CITY OF ALBUQUERQUE

November 20, 2018

**Re: McDonalds - 8315 Montgomery Blvd NE
Tract A-1-F of the Los Pastores Shopping Center
Grading and Drainage Plan - Engineer's Stamp dated: missing (F19D013A)**

DRAINAGE SUMMARY REPORT

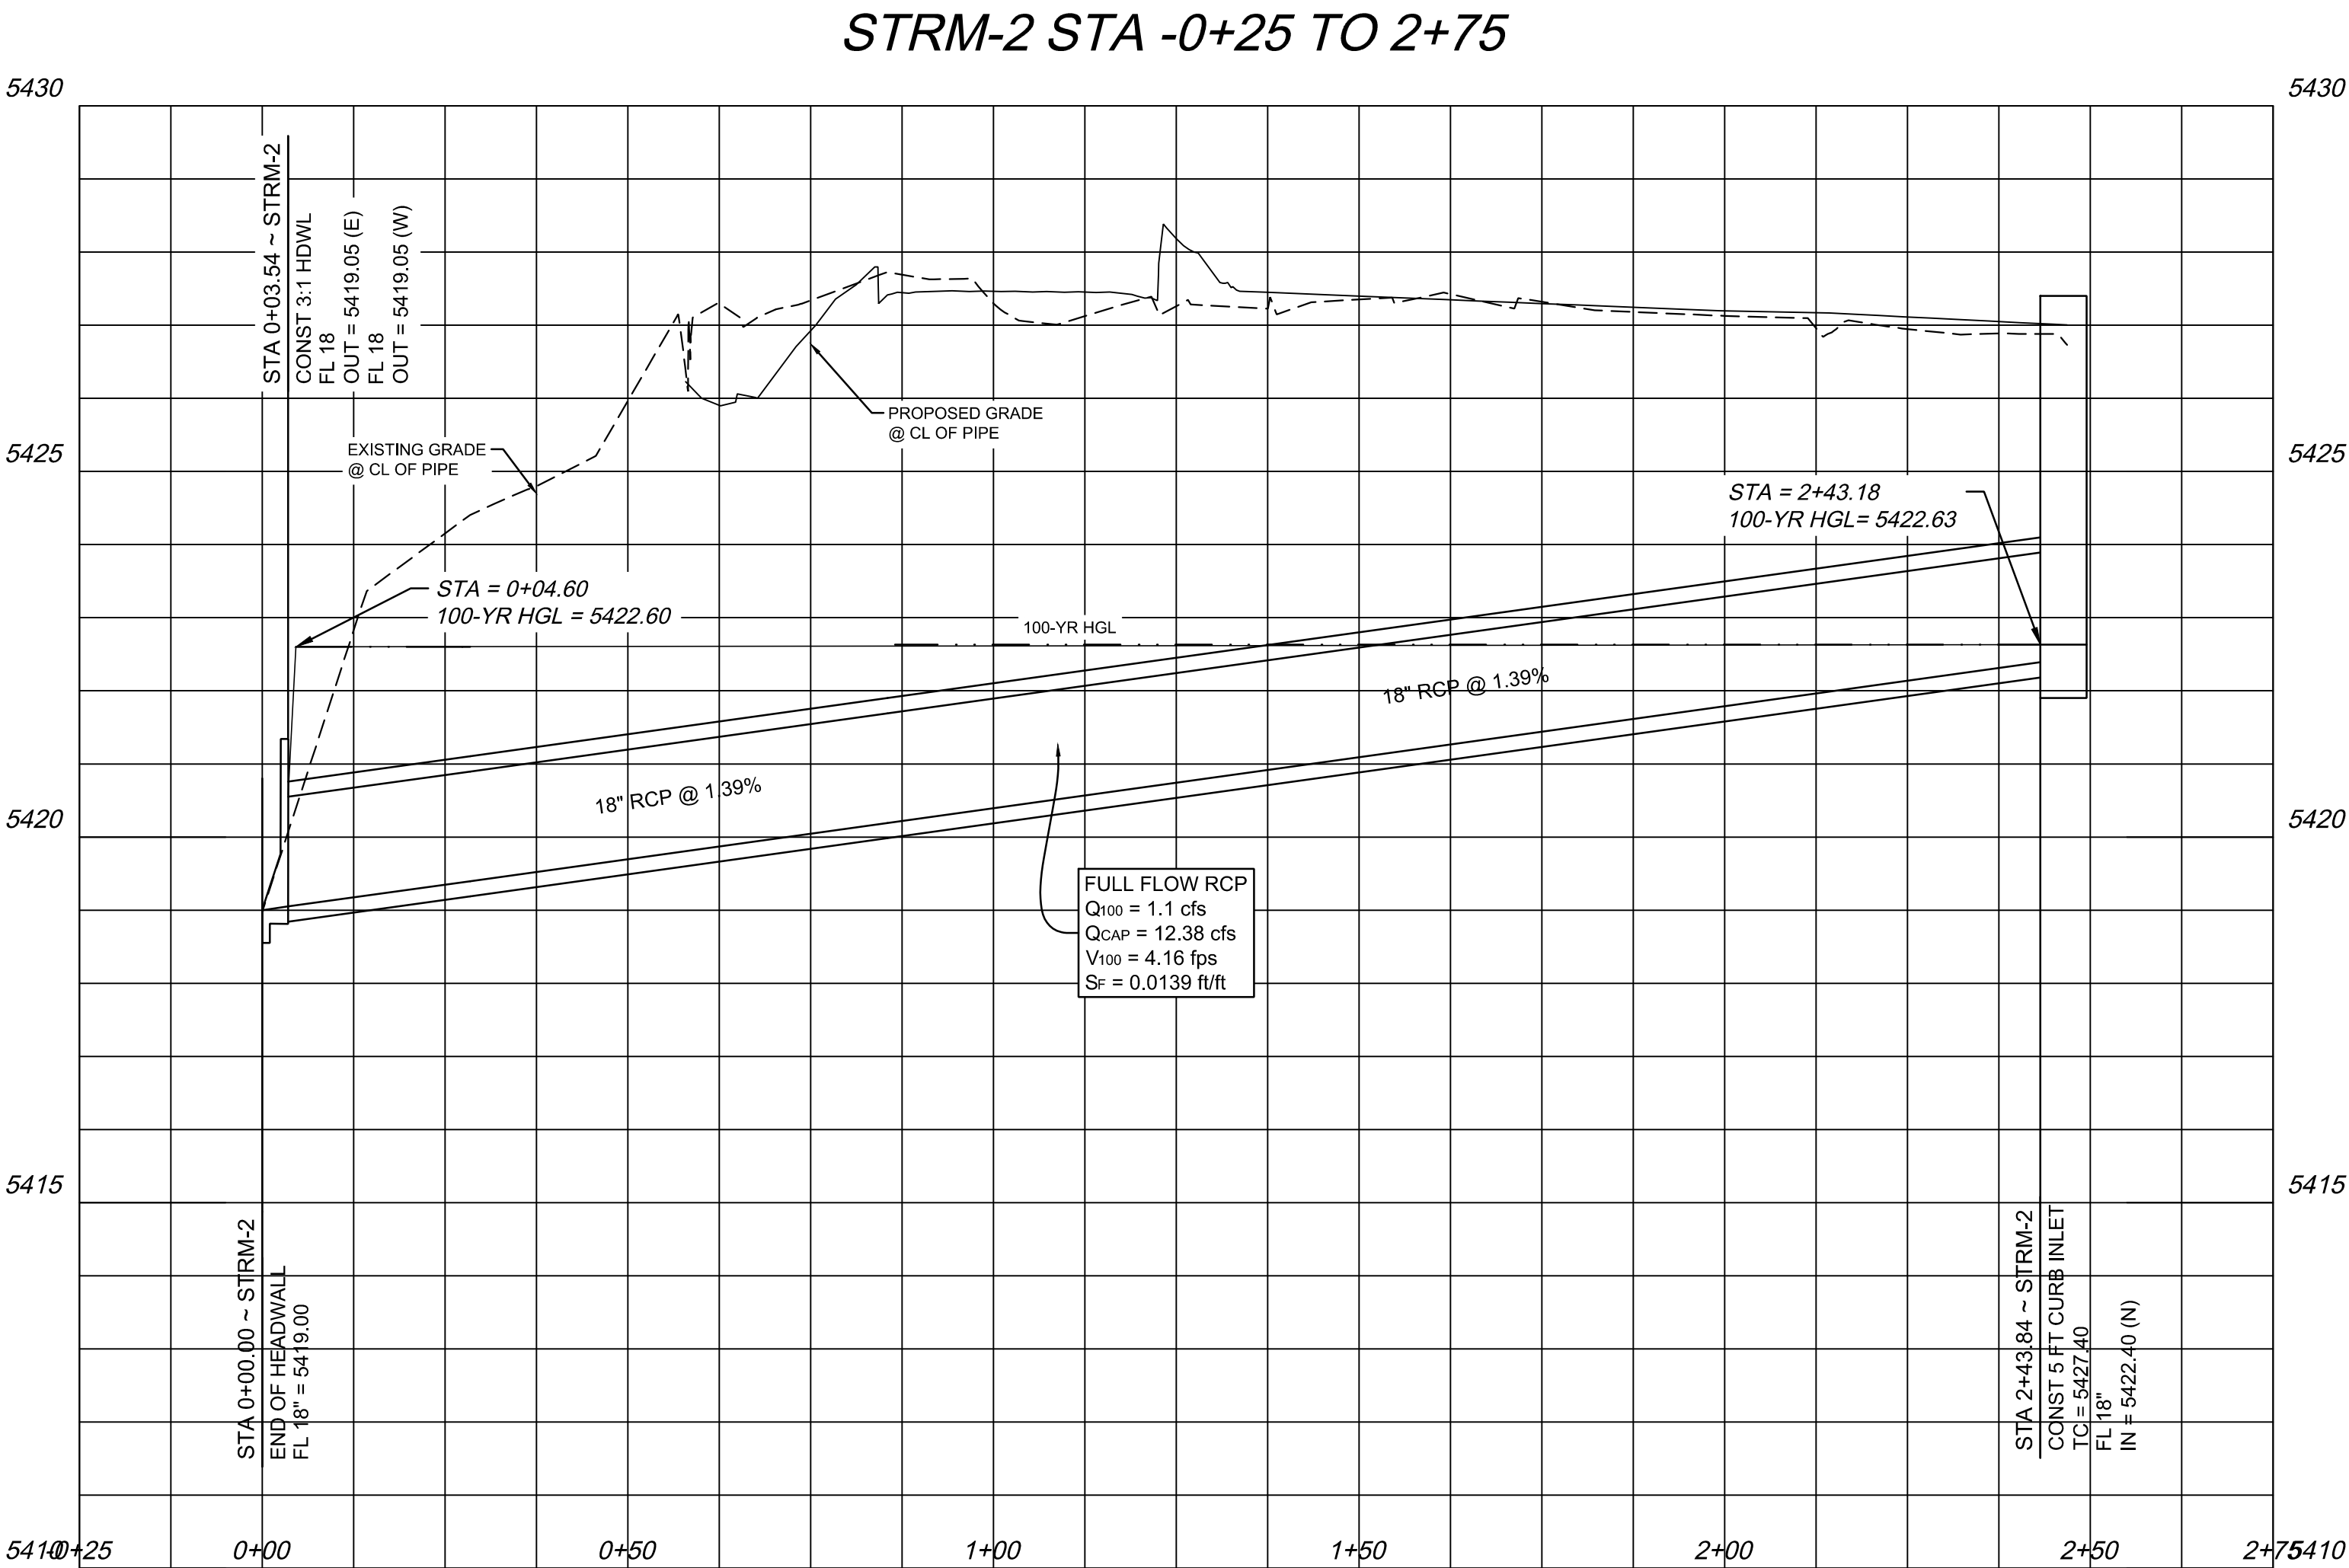
6. The drainage management summary on sheet 8.1 needs to be revised to include discussion of the diversion of flow from the Los Pastores Pond and the limited capacity downstream of this site in the alley and in Montgomery. The narrative should acknowledge the Drainage Management Plan for the Los Pastores Shopping Center and discuss specifically how the proposed site will conform to that plan. This level of analysis, hydrograph development, pond routing, and detailed hydraulic analysis is more easily bound into a report than spread out on 24" x 36" sheets, but either way the calculations must be stamped and signed by a registered Professional Engineer in the state of New Mexico.
